# Submission to Planning Inspectorate Re Fosse Green Energy Ltd - EN010154

Deadline 6 – 31 May 2026

Carl Koenen – IP No: [REDACTED] - Resident of Thorpe on the Hill

Indicative PV Array Cross-Sections

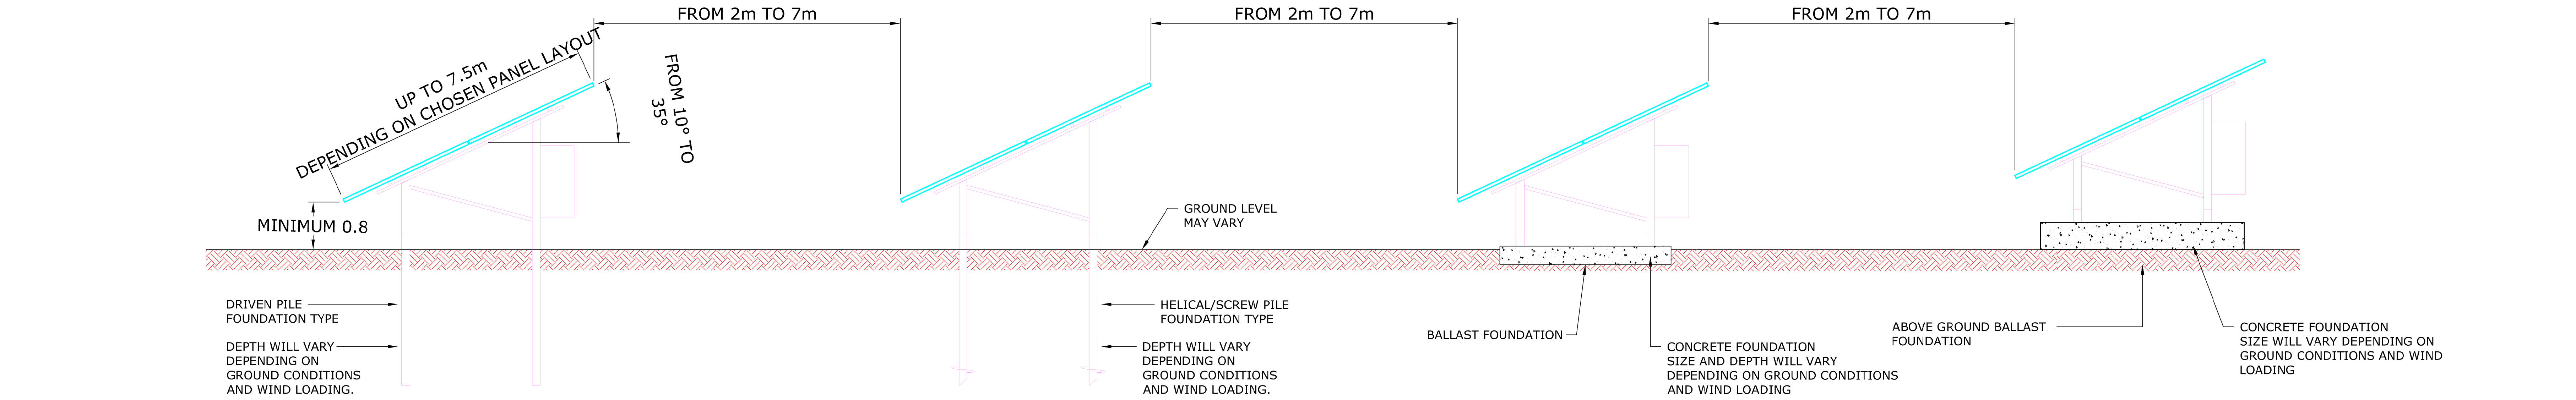
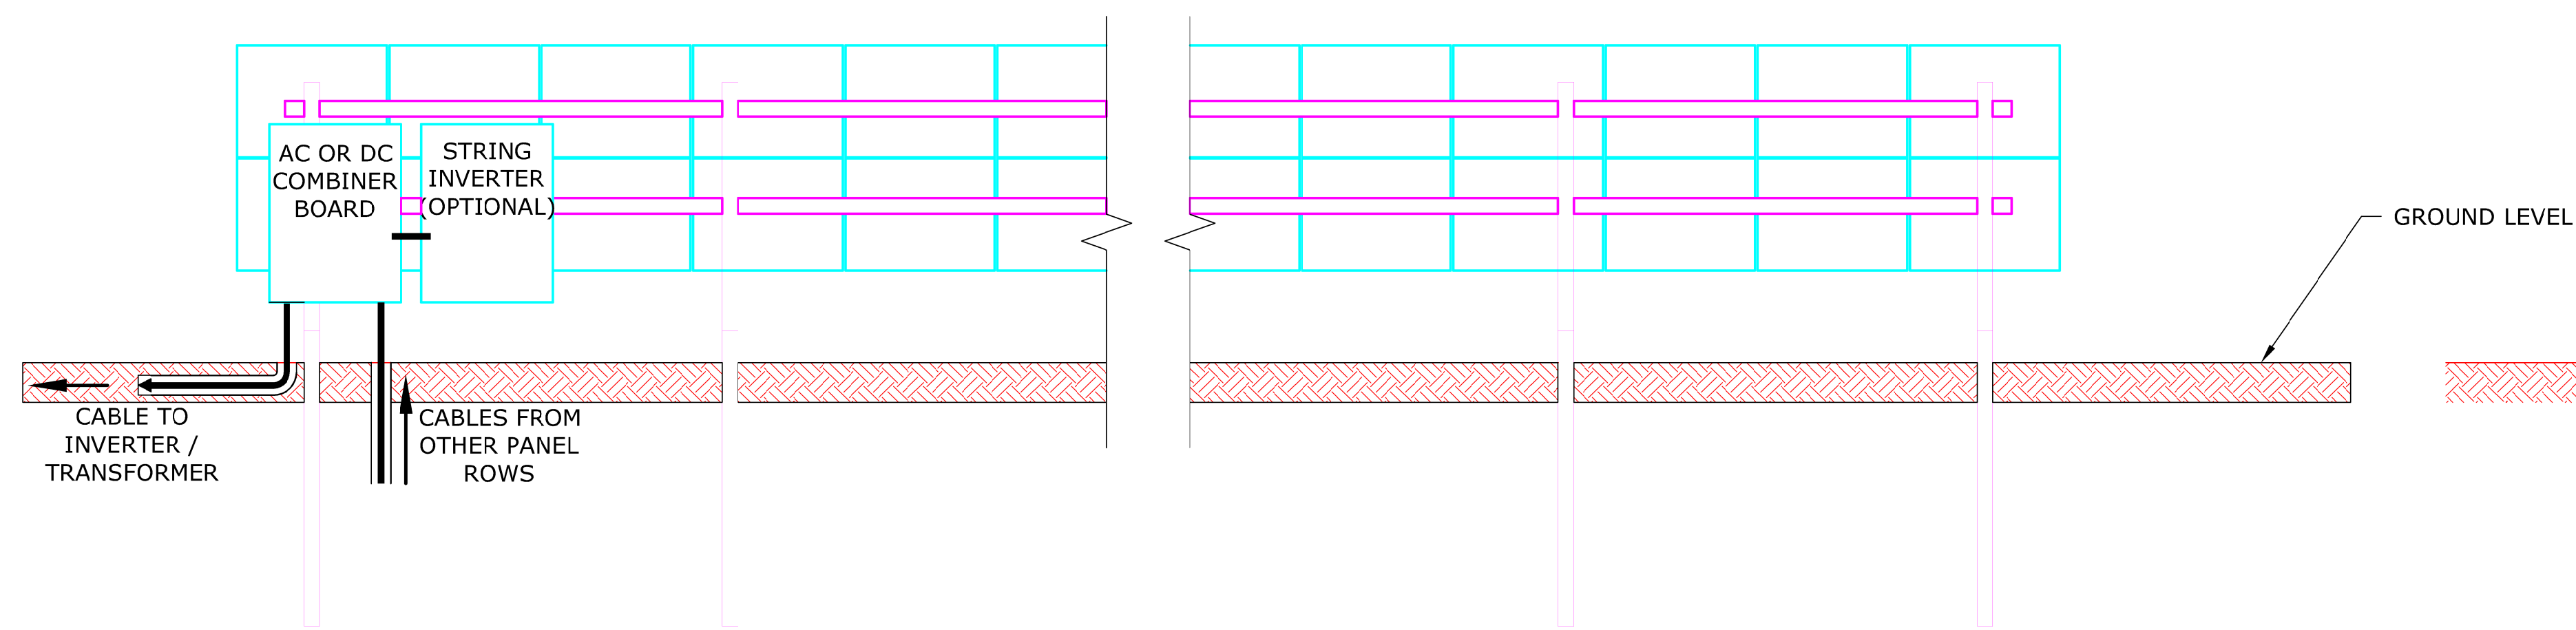
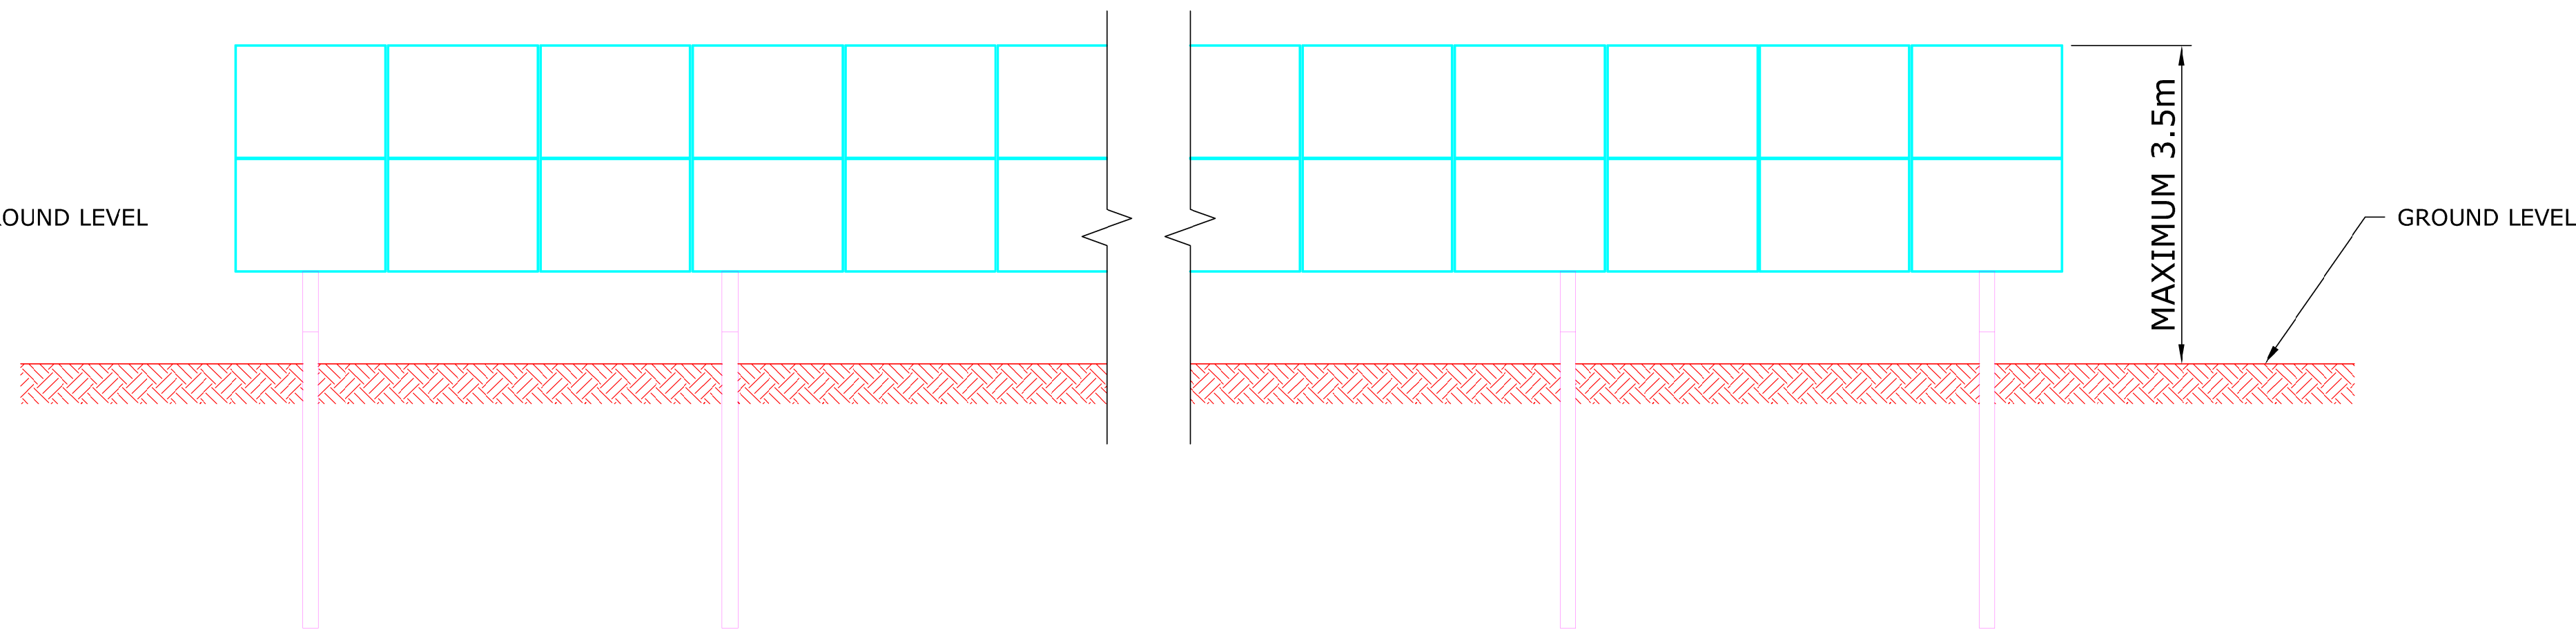
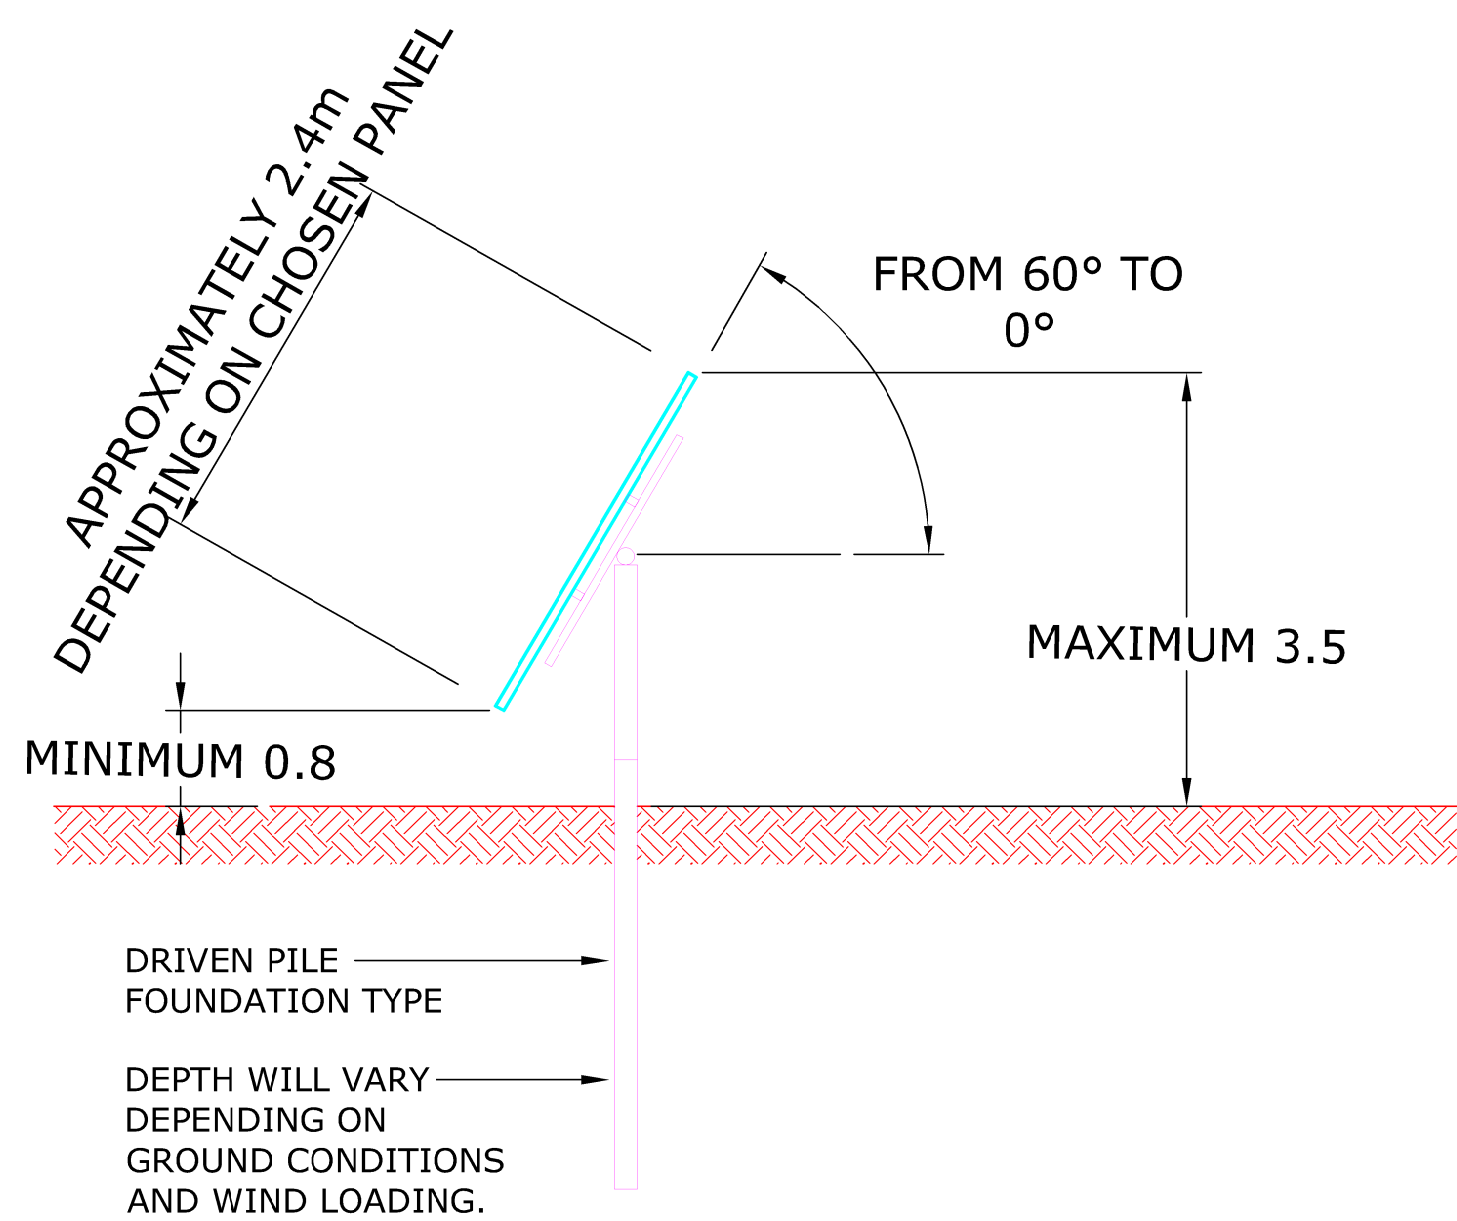
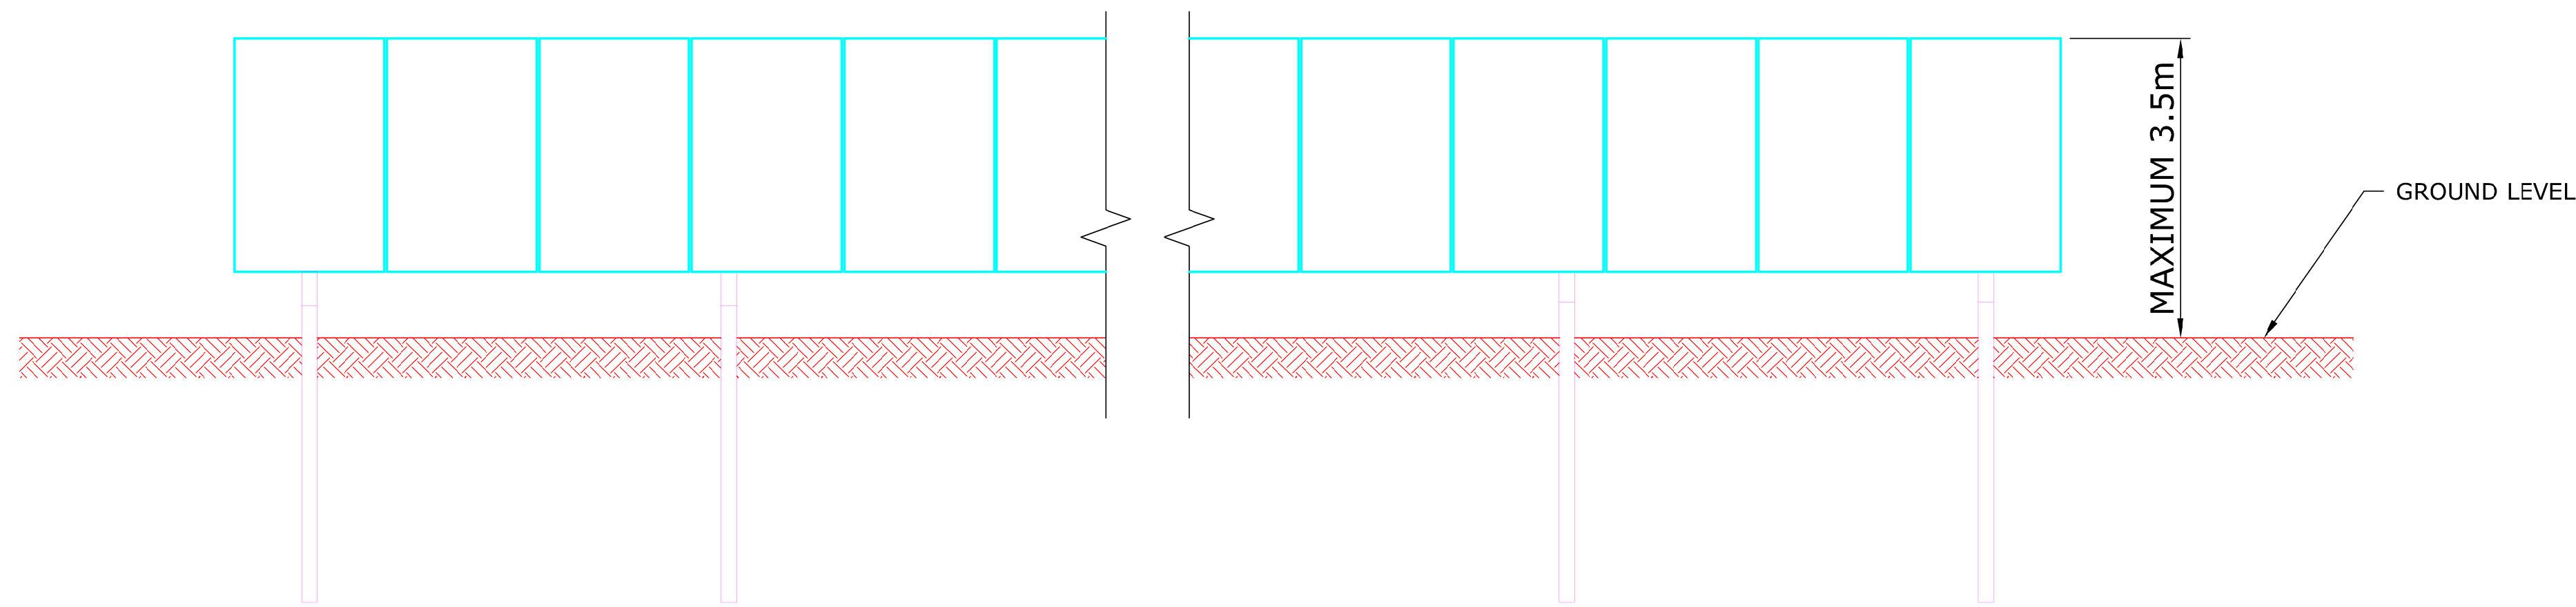
4. The Applicant suggests in their APP 028 6.1 ES Chapter 3 The Proposed Development that:

*Currently individual panels are typically up to 2.4m in height by 1.3m in width and consist of a series of PV cells beneath a layer of toughened glass with an anti-reflective coating (as shown in Plate 3-1 and Plate 3-2, which are two common panel arrangements). Other PV technologies are developing rapidly and may be available at the time of construction, and therefore to allow flexibility for future module technology to be larger, the maximum solar PV table (i.e. solar PV panels fixed to the mounting structures) height parameter considered within this ES is 3.5m above ground level (AGL).*

Please note that here the Applicant says "...to allow flexibility for future module technology to be larger.....that a height of 3.5m above ground would be possible."

So instead of anticipating future arrays to be more compact they consider they would be larger. With a 60-year term for the proposed development and a life time of 30-40 years for the panels this potentially would mean a far larger set of arrays to cover the landscape than were originally installed
